| Application No. | 2024/92365 |

**Consultation Response from KC,
Lead Local Flood Authority**

**2024/92365 Land off, Blackmoorfoot Road and Felks Street, Crosland Moor, Huddersfield, HD4
7AD**

Date Responded: 19th October 2025

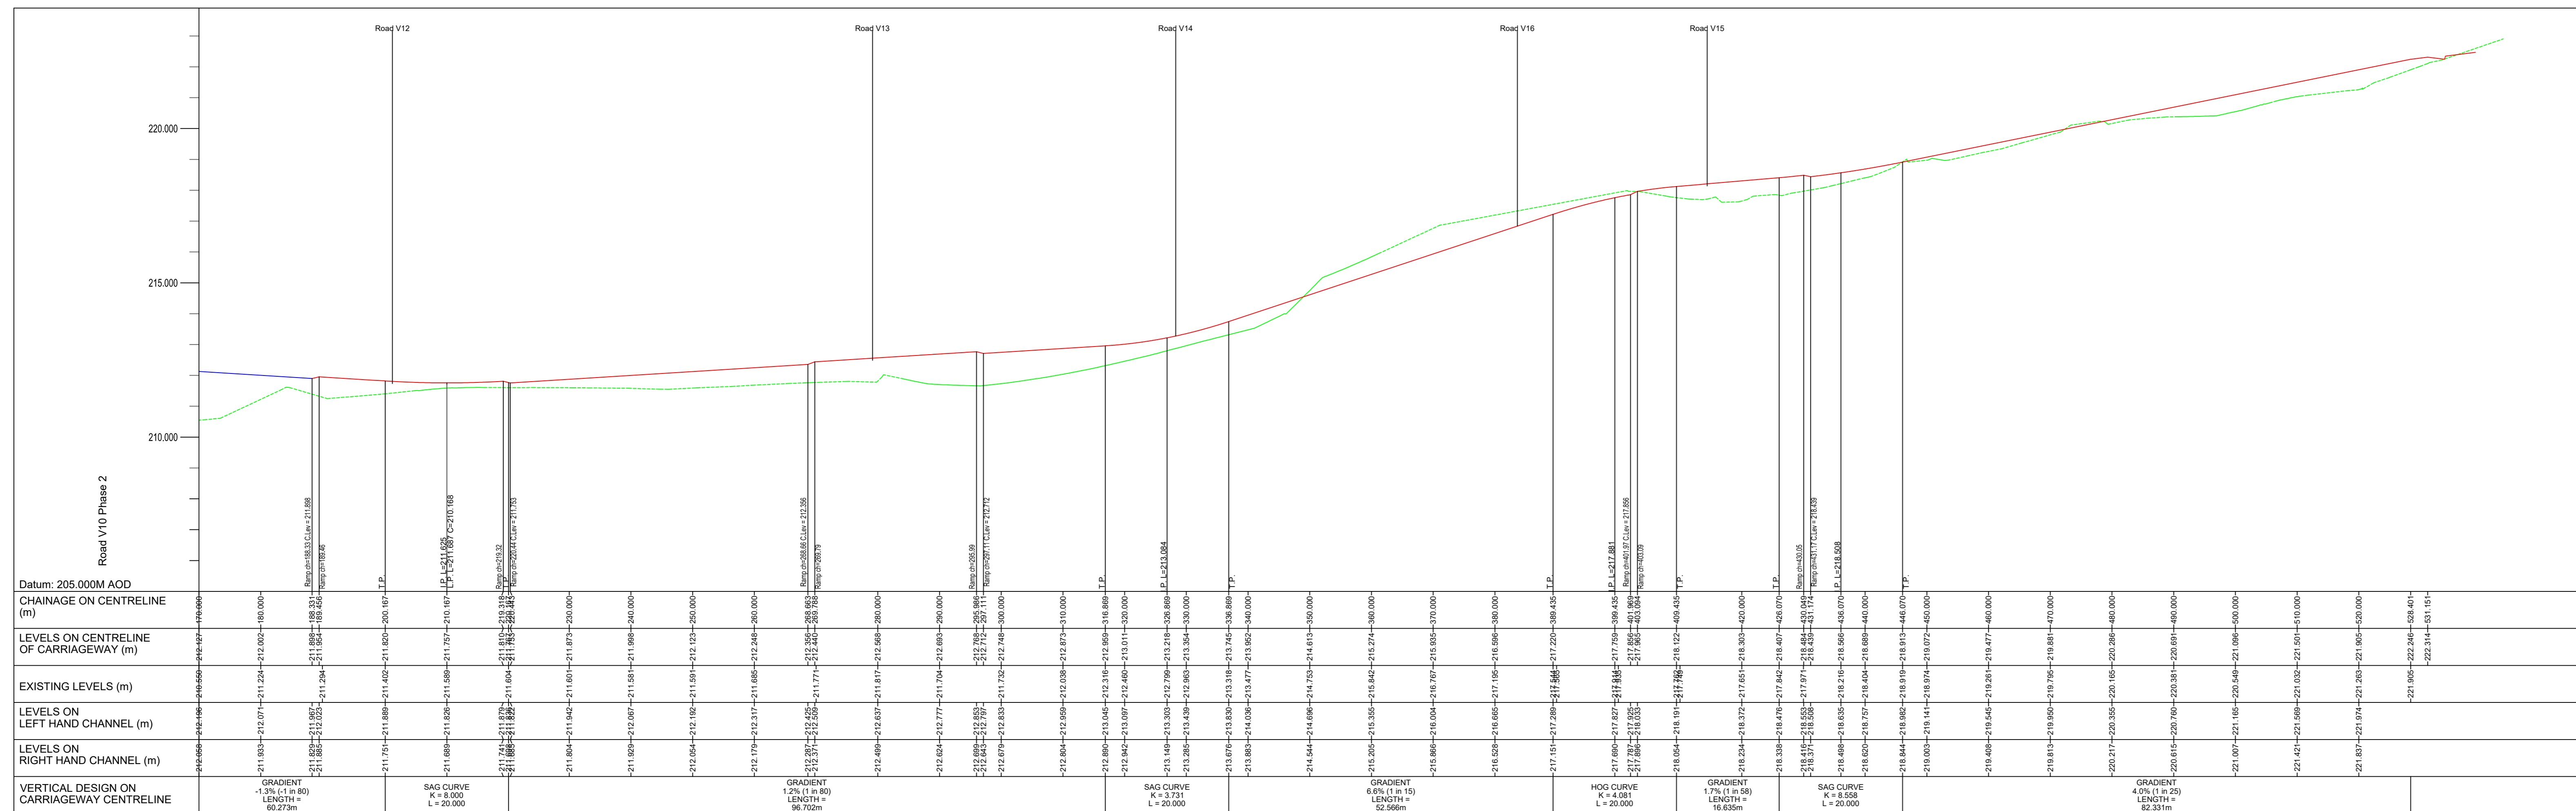
“The outline application raised concern over indicative flood routing. Whilst a submission has been made to show actual routing through the eastern section of the wider site, a more detailed plan is required. Road contours extended onto pavements with levels clearly indicated is required as an ‘Engineering Layout’. This should include back of kerb levels and levels and direction of fall with gradients on private access drives and driveways.”

Road contours are not labelled with an level AOD.

Direction of fall on driveways also not labelled.

If finished floor levels are available this would also support the application.
